Draft SOCG with the Environment Agency

River Humber Gas Pipeline Replacement Project

Statement of Common Ground - Environment Agency

RIVER HUMBER GAS PIPELINE REPLACEMENT PROJECT		
INDICATIVE PAULL SITE LAYOUT FIGURE 2.4 B		
REFERENCE		
DRAWN	CHECKED	APPROVED
JN	KB	NH
SCALE	ORIG SIZE	SHEET
1 : 1000	A1	1 of 1
DATE		REVISION
12 OCT 15		03

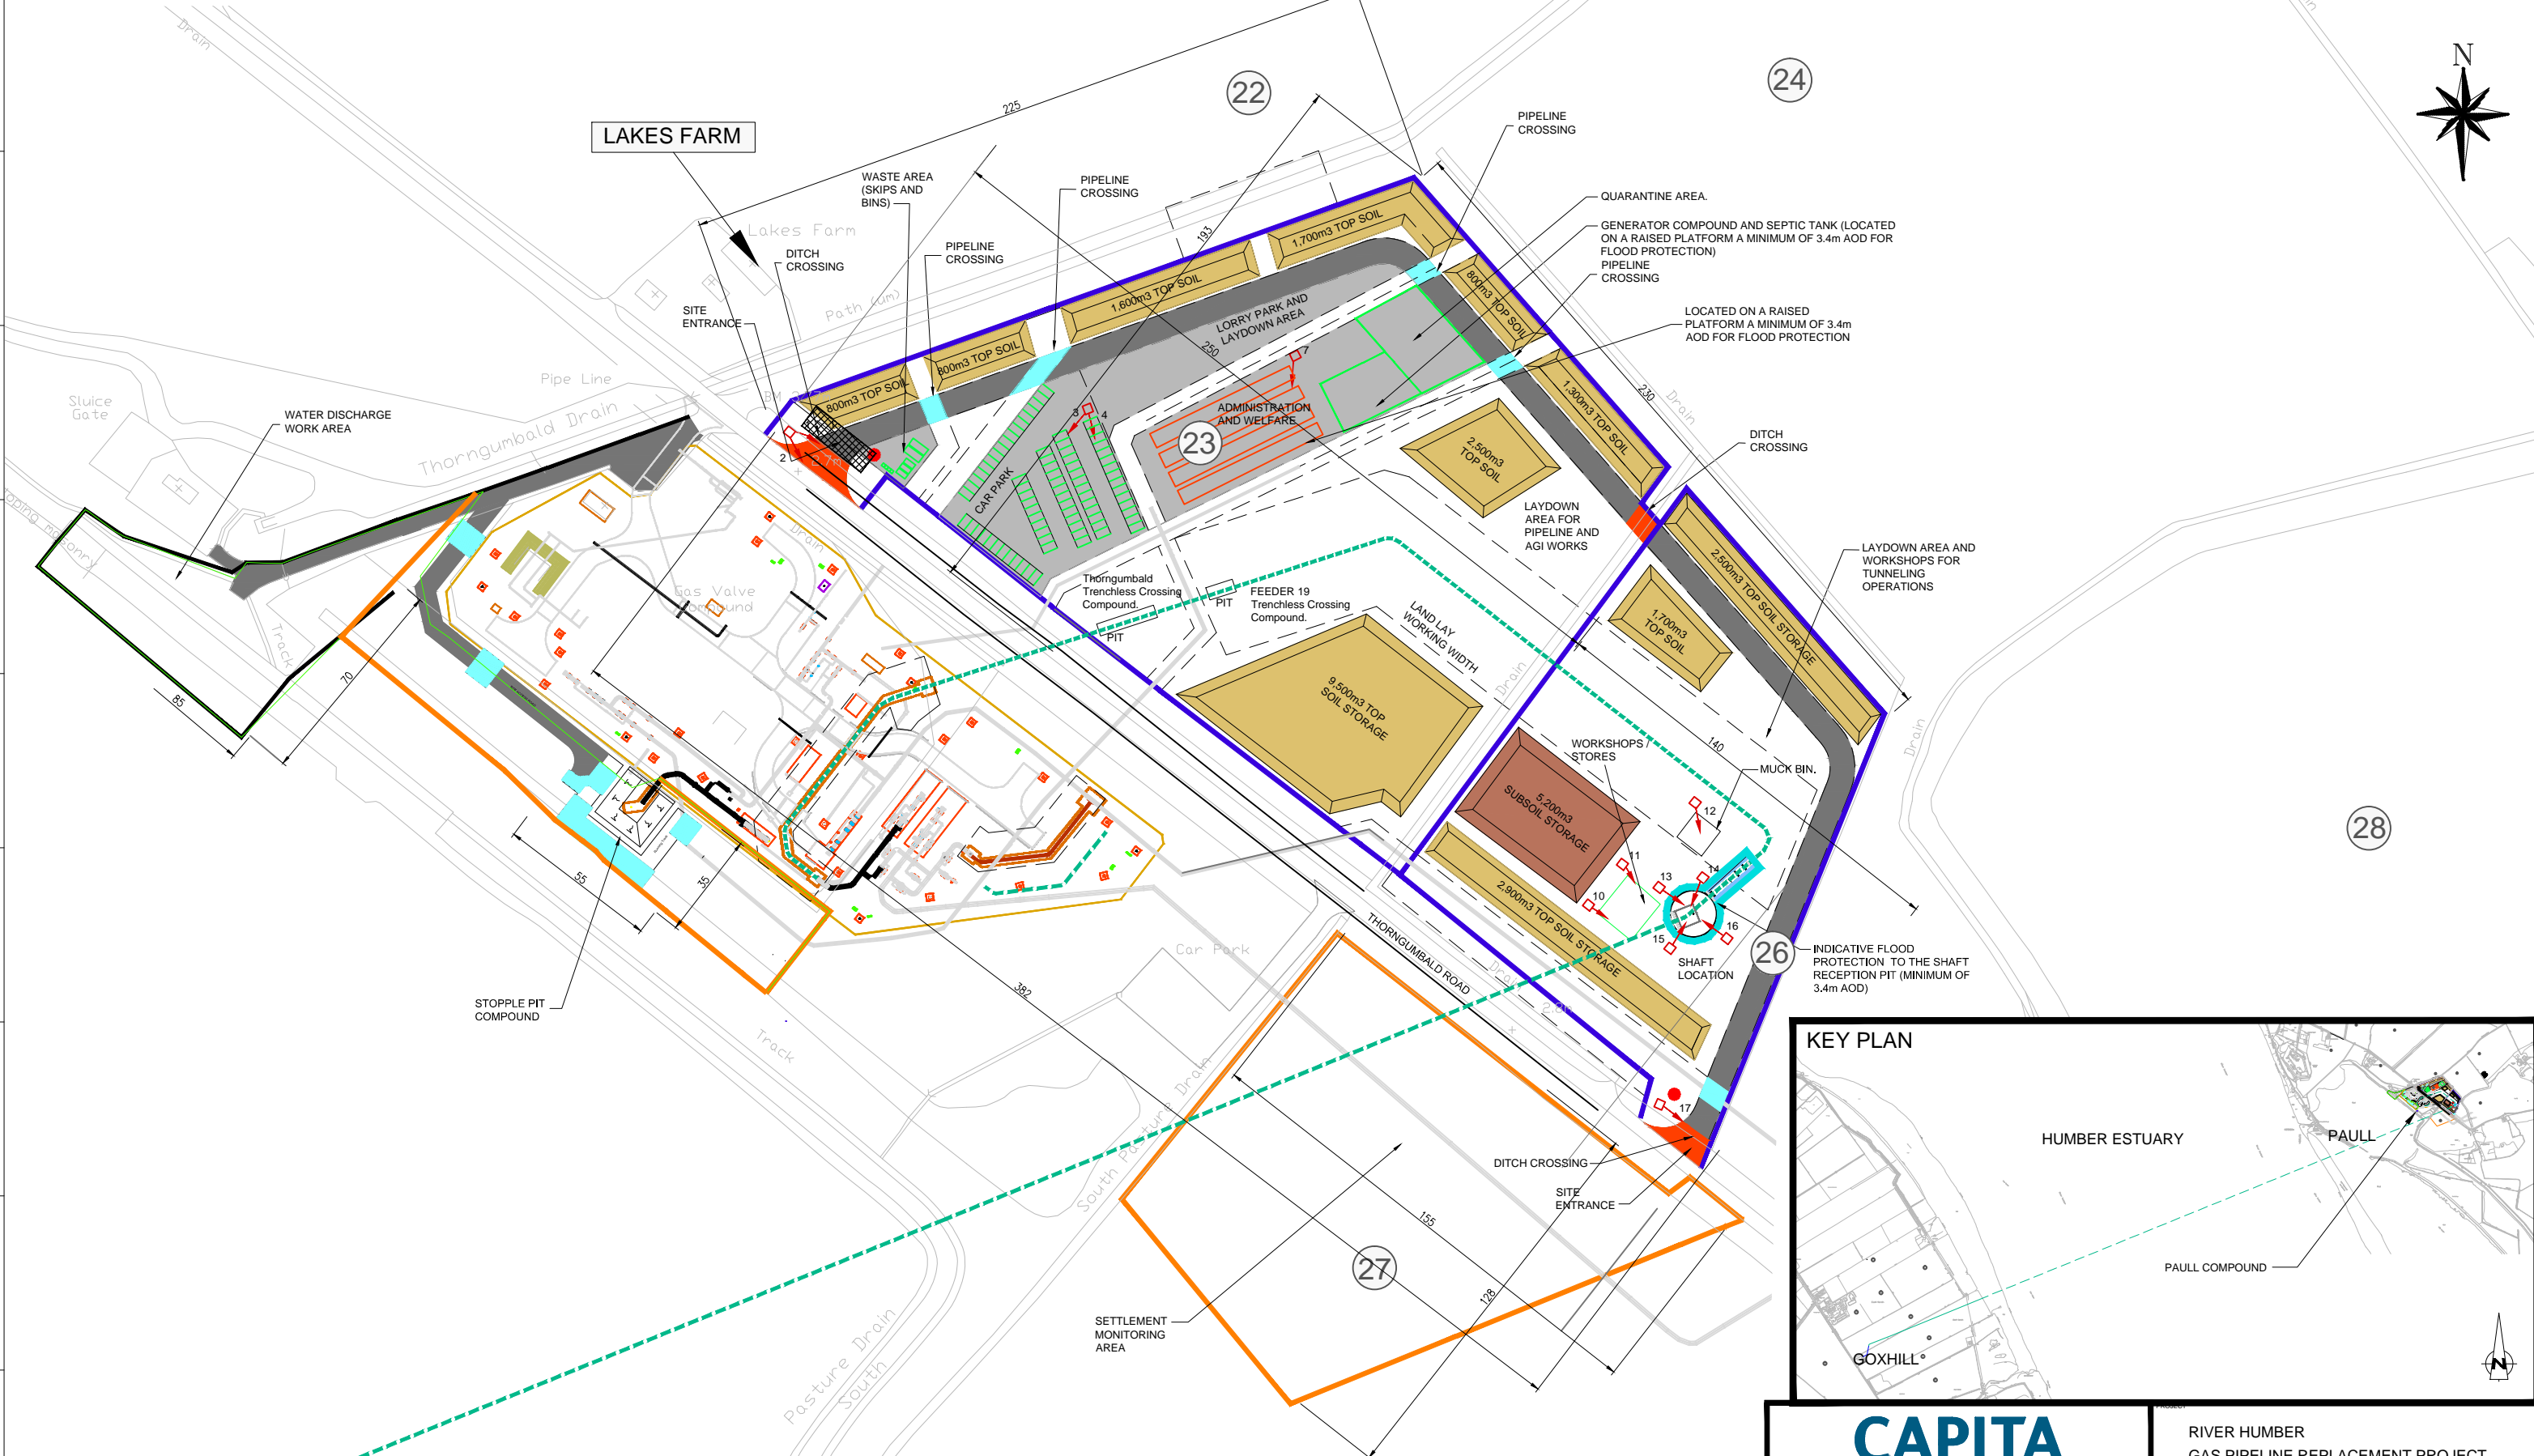
The design team has confirmed that the water discharge area illustrated in Figure 2.3 'Indicative Paull Site Layout' comprises of hoses over the flood defence to facilitate discharge of brackish and freshwater. Unhindered access to the defences will be maintained and no intrusive interference with the defences in this area is required. Design team
